**Proposal:** Discharge of Condition 7 (stone sample panel) of 21/03947/F

BOCO-030-AA  
12/06/2023

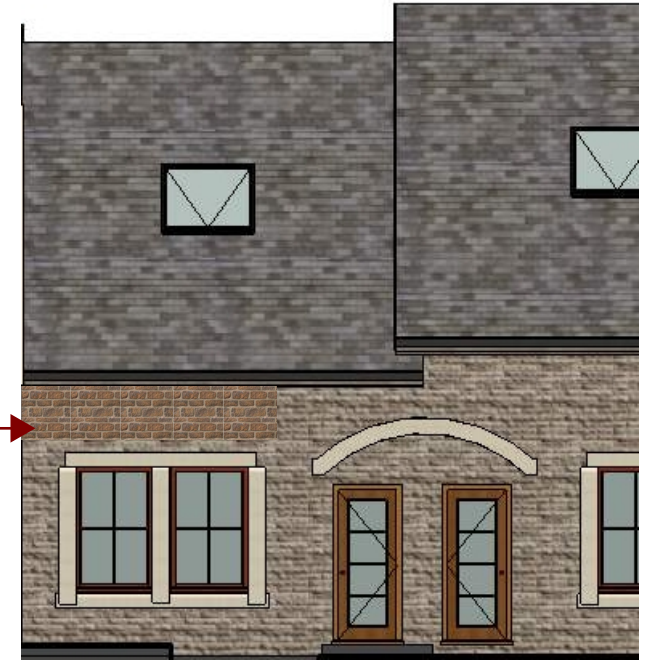
- 6.3. Whilst the stone which has been used in the construction of this sample panel is considered to be appropriate for use in this location and would appropriately match and respect the existing stonework at the site, it is considered that the way the stone has been laid, dressed, coursed and pointed is not acceptable and does not match the existing stonework at the application site.

- 6.4. The mortar joints are considered to be significantly thicker than the original wall shown behind in the picture and the stone work has been laid too square with stones laid directly on top of each other rather than being staggered as is seen on the original stonework to the rear of the sample panel.

The stone sample panel erected on site is unacceptable as the way the stonework has been laid, dressed, coursed and pointed, including the excessively large mortar joints, does not match the stonework on the existing building. The proposed stonework would appear unsightly and detract from the original character and appearance of the main building. It has not been demonstrated that the development would safeguard the character and appearance of the area. The proposed stone sample panel is therefore contrary to Policy ESD15 of the Cherwell Local Plan 2011-2031 Part 1, Saved Policies C28 and C30 of the Cherwell Local Plan 1996 and Government guidance contained within the National Planning Policy Framework.
